Subject: FP/36/12 - Extension of Temporary Access into Phase 1 of Felpham Development.

Drawing Title:
TEMPORARY ACCESS ROAD
PHASE 1 LAYOUT

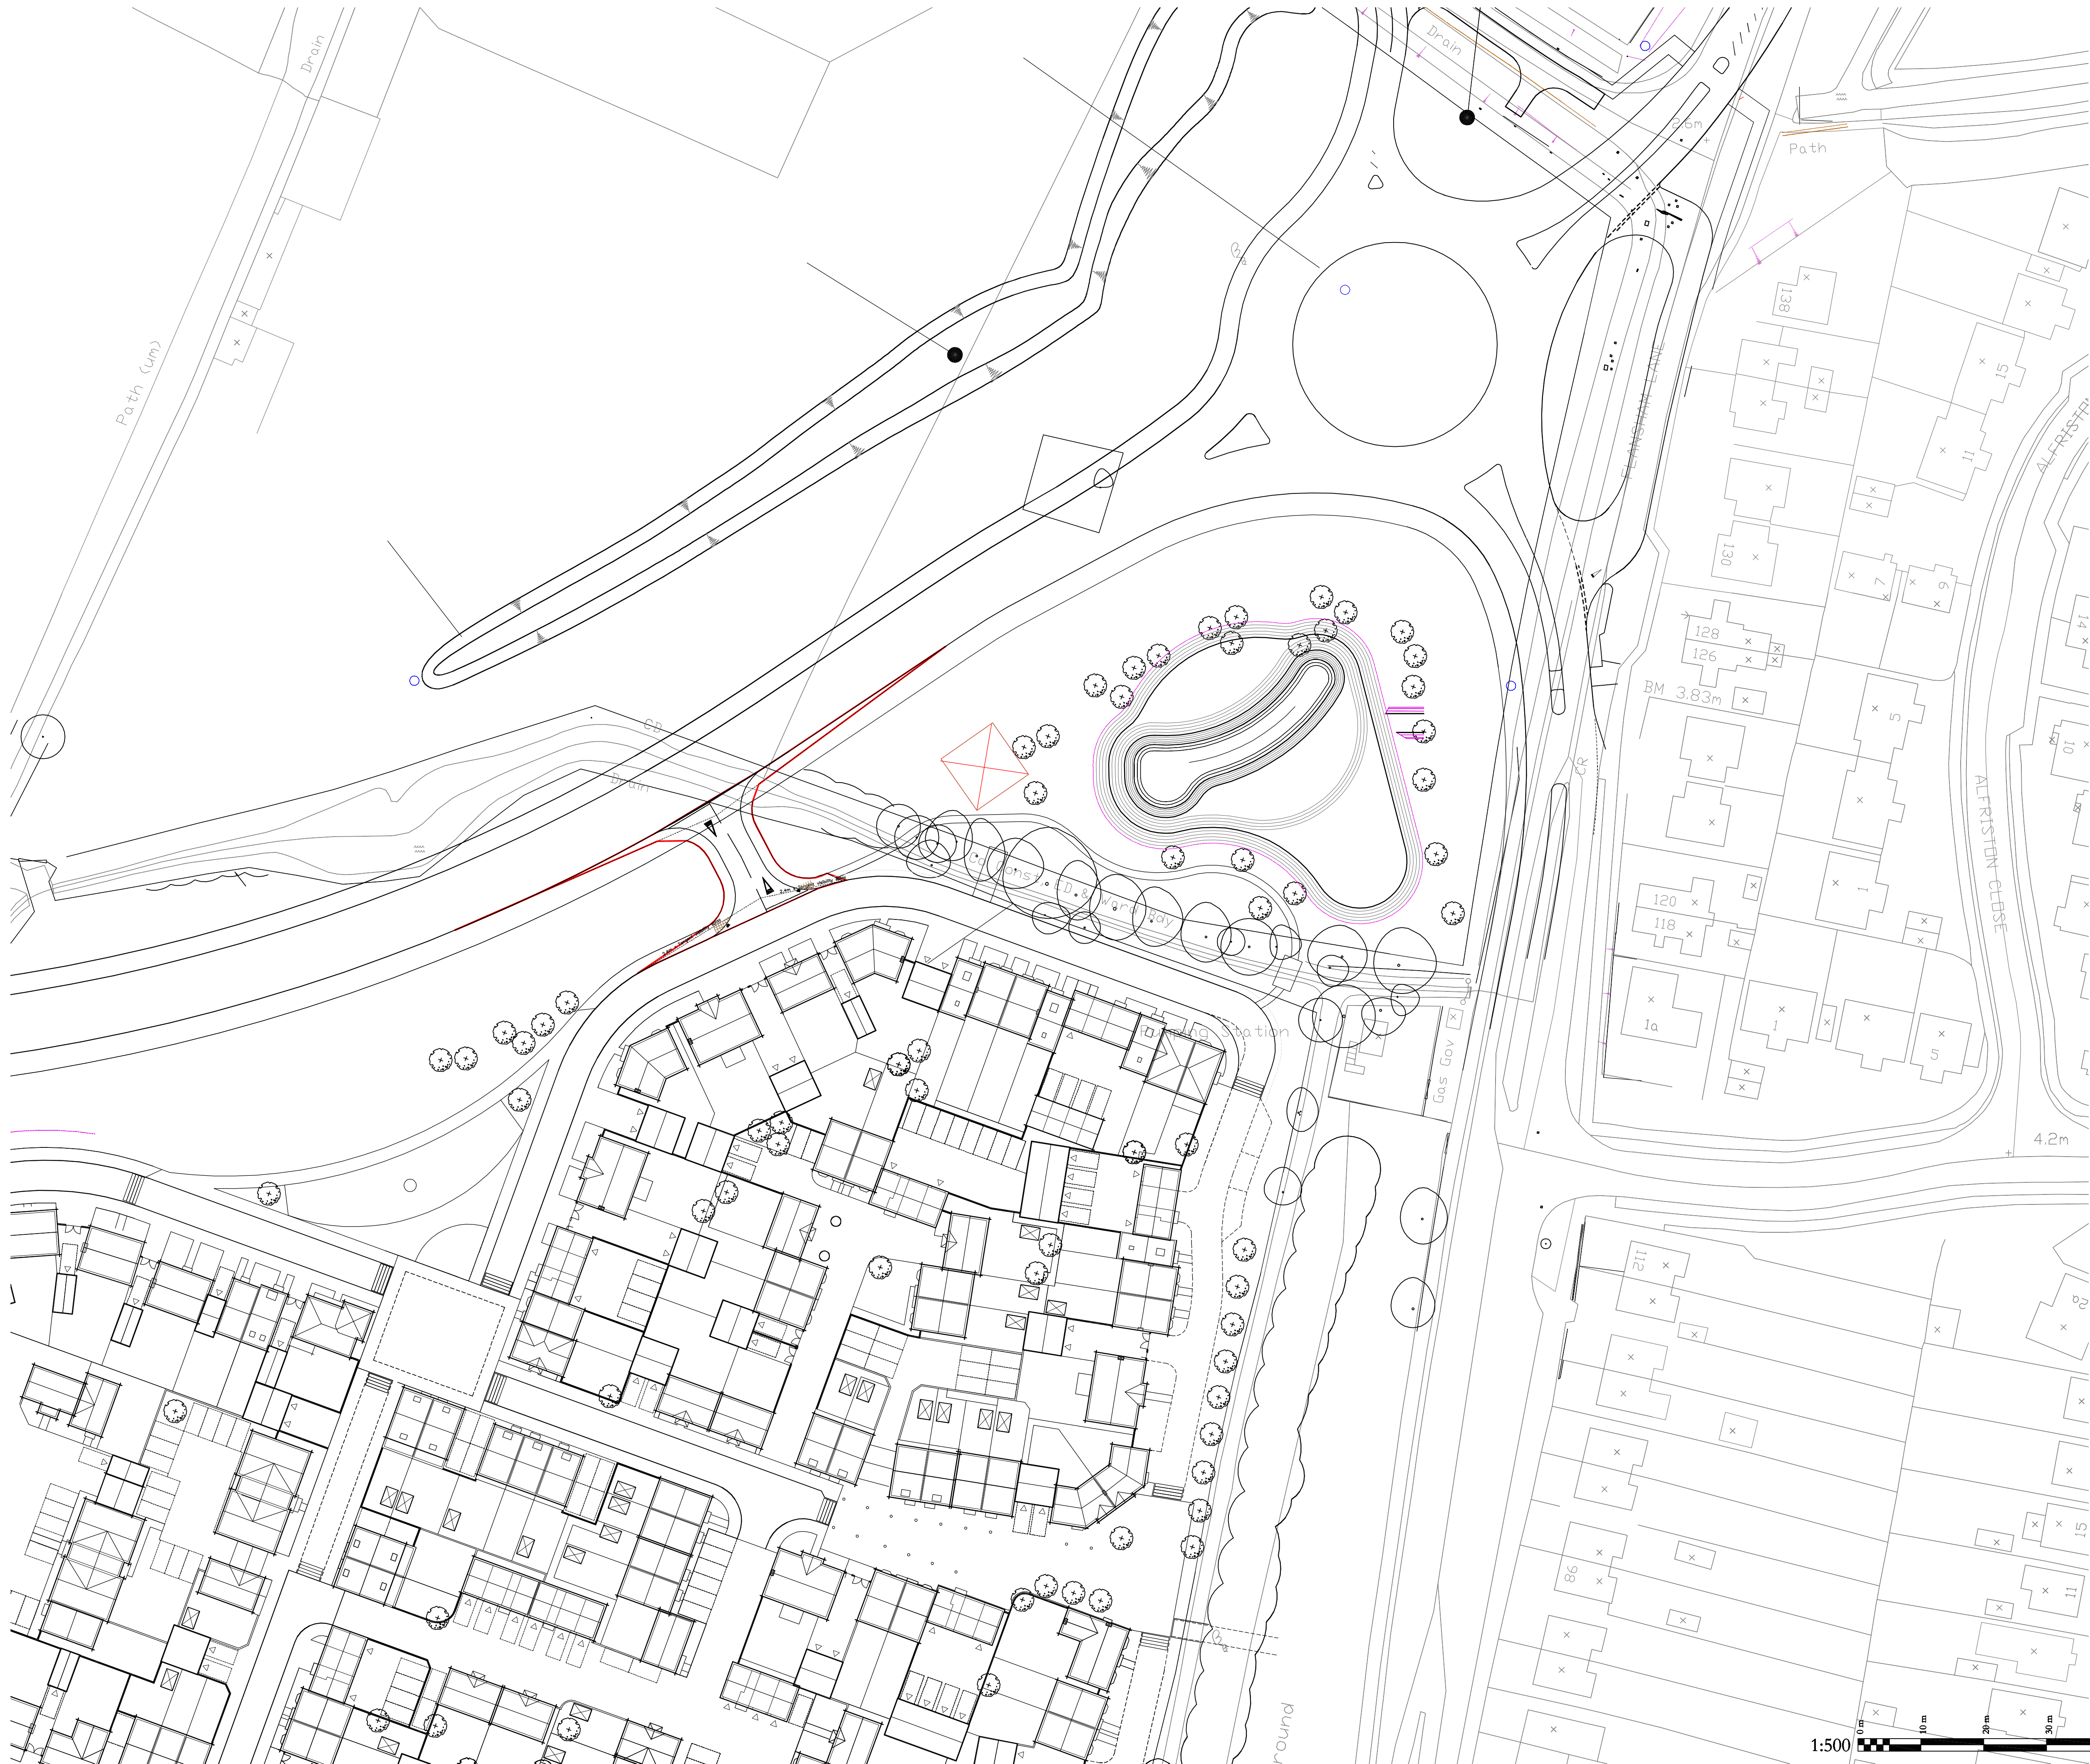
The County Council have raised an objection to the 18 month extension of the operating period of the temporary access into Phase 1 of your development at Felpham on the basis the available visibility is not appropriate for a new public highway with a 40 mph speed limit. The road will become a public highway once complete in November 2012.

However, if a drawing can be submitted that shows the requisite visibility standard can be met our position will be reconsidered and a revised response issued to Arun District Council.
